**From:** Richard Castro-Parker  
**Sent:** 05 March 2019 11:52  
**To:** Planning.Responses  
**Subject:** FW: land near windmill barn, pagham road - P/94/18/PL

**From:** Laura Gibbons  
**Sent:** 05 March 2019 11:23  
**To:** Richard Castro-Parker  
**Subject:** land near windmill barn, pagham road

Dwg No.: SBS/423/01 A

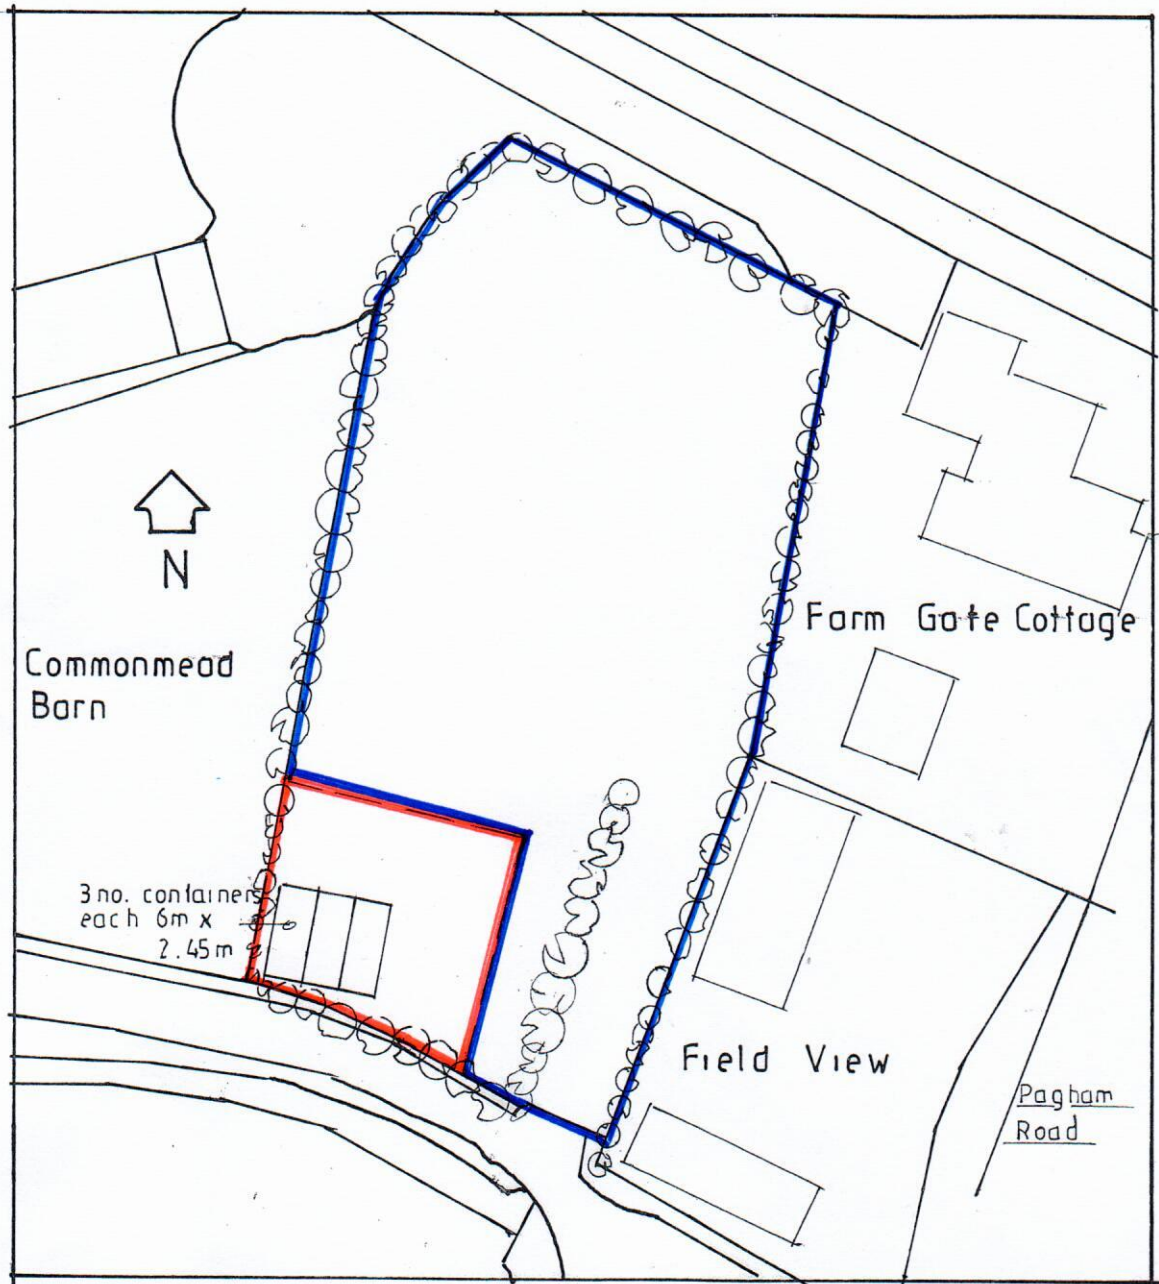
As discussed, I am happy to remove our request for the condition for easement to watercourse as the plans and information provided evidence that the proposed containers will not be sited within 3m of the culverted ordinary watercourse.
